Planning Ref: 22/00336/F

Proposal: Single storey rear extension and canopy over front door – re-submission of 21/00565/F

Location: 1 Meadow Crest Cottages, Burdrop

Sibford Gower Parish Council **OBJECTS** to this application

Existing & Proposed
 Site Plans

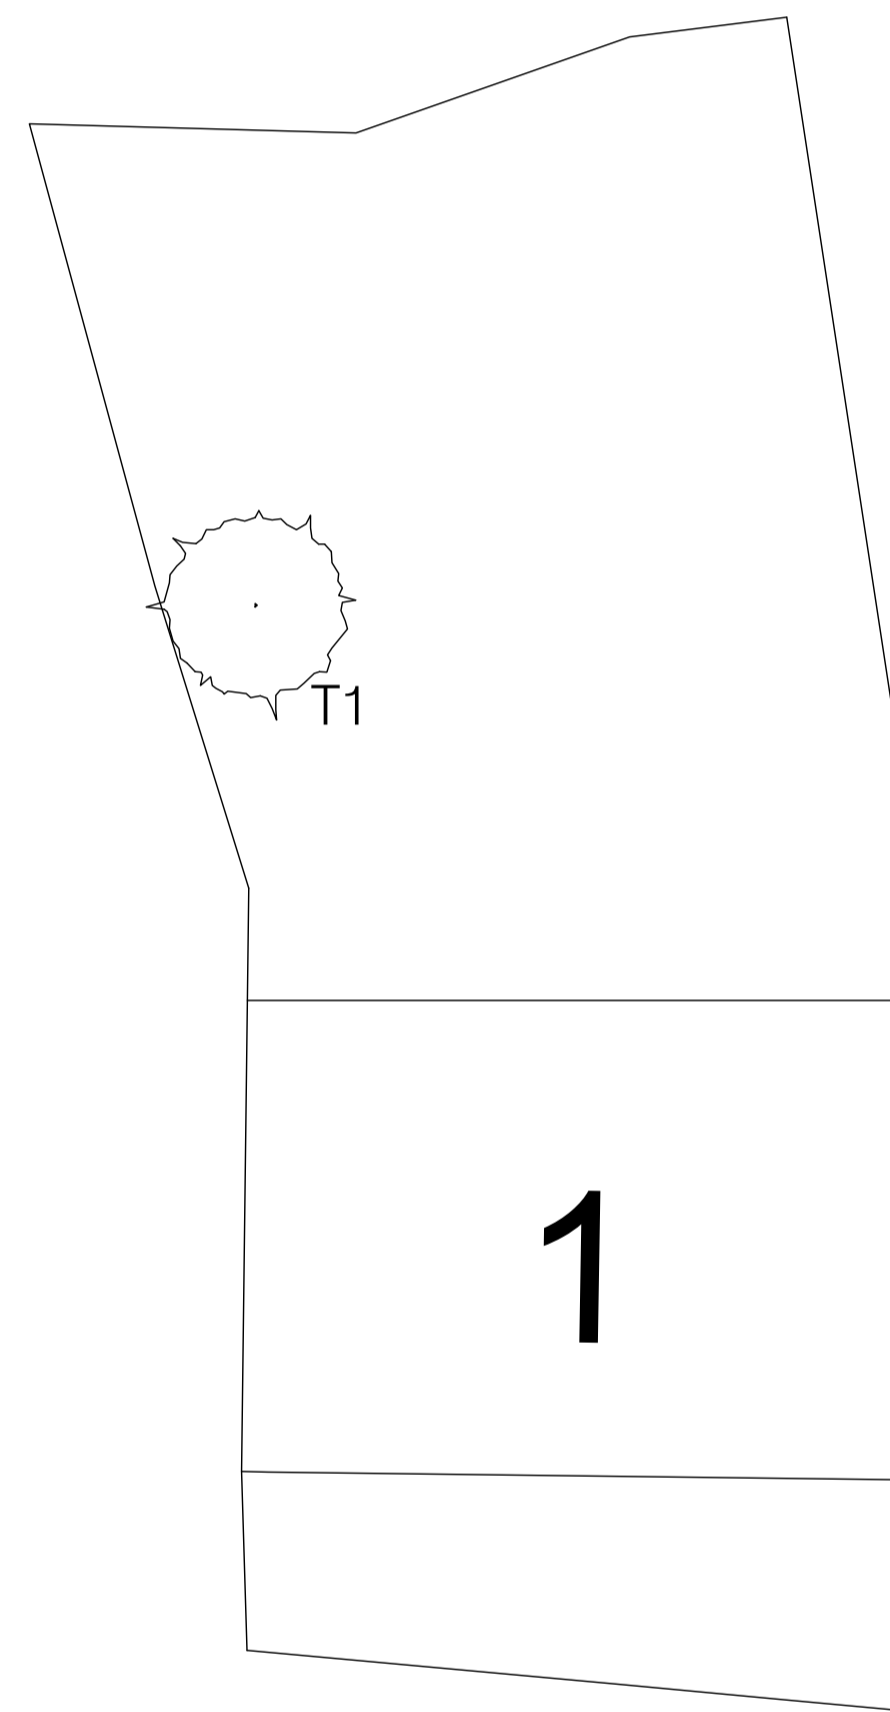
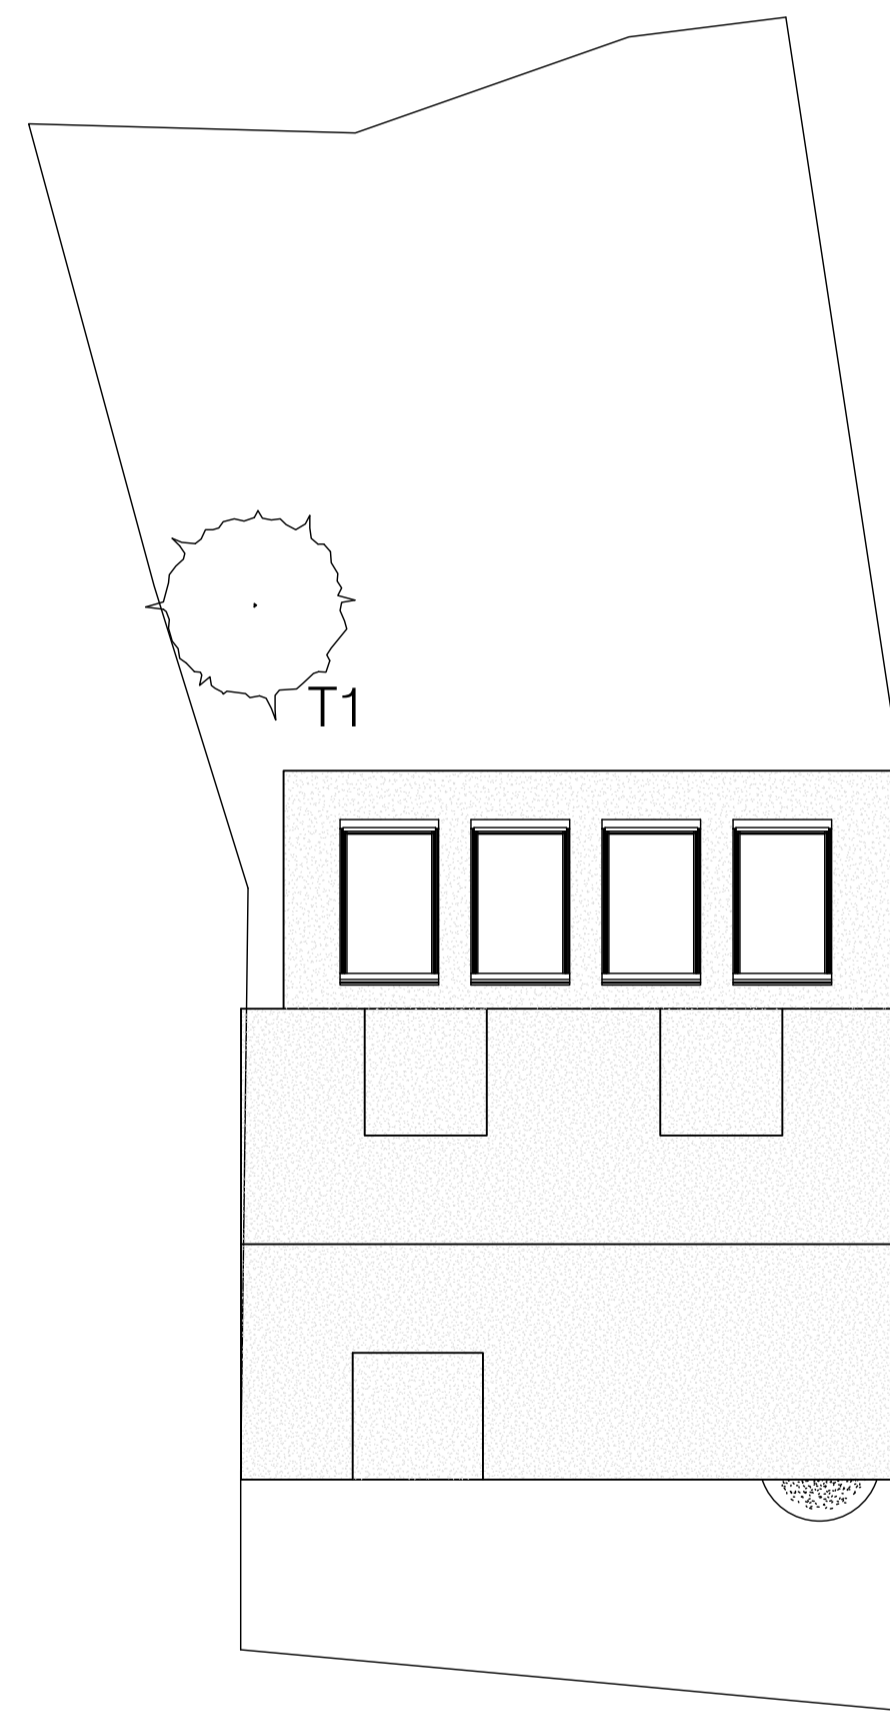
Canopy over front door: The siting of the proposed canopy would cause run-off to fall onto the adjacent property's front door area.

Party wall/Maintenance: The plans show varying detail in addressing potential party wall issues, and offer no provision to facilitate regular maintenance requirements for adjoining properties
